Phone: 0300 123 6780
Email: developeras@lancashire.gov.uk
Your ref: 3/2025/0289
Our ref: 3/2025/0289/HDC/KW
Date: 11 June 2025

Location: Thornley Hall Farm Up Bedlam Road Thornley PR3 2TN
Proposal: Outline application for the proposed erection of a farm workers dwelling with access applied for (all other matters reserved).
Grid Ref: 363549 441223

Title: Proposed Site Plan	
Drawing No: Air/1164/3545/04	Drawn: MP
Client: G.E. Airey & Sons	
Date: 17.07.2025	Scale: 1:250 @ A2
Amendments:

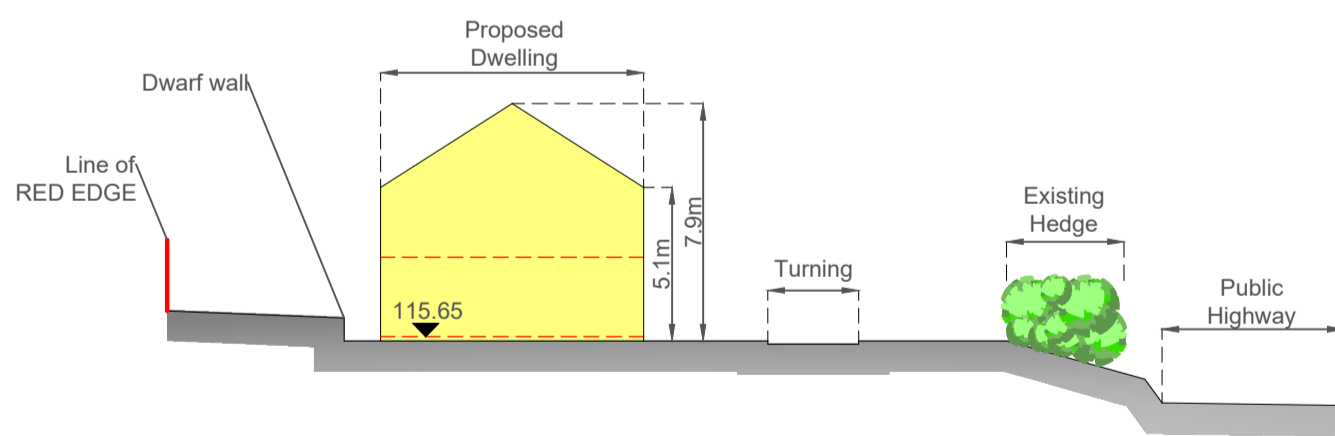
The LHA has reviewed the proposed site plan drawing number Air/1164/3545/02 and note that the access is to be 4.5m wide. However, the visibility splay does not appear to have been drawn correctly on the plan, particularly on the west side. However, the LHA have undertaken their own assessment and found that the visibility splay can be achieved within the red and blue edges of the development; as such, the visibility splay requirements will be conditioned below.

The access is also required to be surfaced in a hard-standing material for at least the first 5m into the site and should have a gradient no steeper than 1:10.

As the site is assessed from Up Bedlam Road, turning provisions should be provided within the site to enable ingress and egress in forward gear. The LHA note that these are proposed from the proposed site plan.

The proposed site plan also includes a garage as such the LHA would advise the applicant that the recommended minimum internal dimensions for a single garage size is 6m in length and 3m wide and for a double garage, it is 6m in length and 6m wide. The recommended distance of 6m is based on the length of a large family car (Ford Mondeo Estate 4.58m long), clearance at the rear of the car (200mm), overhang of the garage door (600mm) and room to stand in front of the car and open/close the garage door (600mm). Where garages are smaller than the recommended minimum internal dimension they should not be counted as a parking space and the applicant should provide an additional parking space elsewhere.

As the access slopes towards the adopted highway, the access is required to include drainage that is drained to a suitable internal outfall, which will be conditioned below.

1. No building shall be occupied until visibility splays 2 metres back from the centre line of the access and extending 47 metres to the East and 48 metres to the West on the nearside carriageway edge have been provided at the access. Nothing shall be erected, retained, planted and / or allowed to grow at or above a height of 0.9 metres above the nearside carriageway level which would obstruct the visibility splay. The visibility splays shall be maintained free of obstruction at all times thereafter for the lifetime of the development.

2. The surface water from the approved access should be collected within the site and drained to a suitable internal outfall. Prior to commencement of the development details of the drainage strategy shall be submitted to and approved in writing by the Local Planning Authority. The scheme shall be implemented in accordance with the approved details.

3. Before the access is used for vehicular purposes, that part of the access extending from the highway boundary for a minimum distance of 5m into the site shall be appropriately paved in tarmacadam, concrete, block pavements, or other hard material to be approved by the Local Planning Authority.
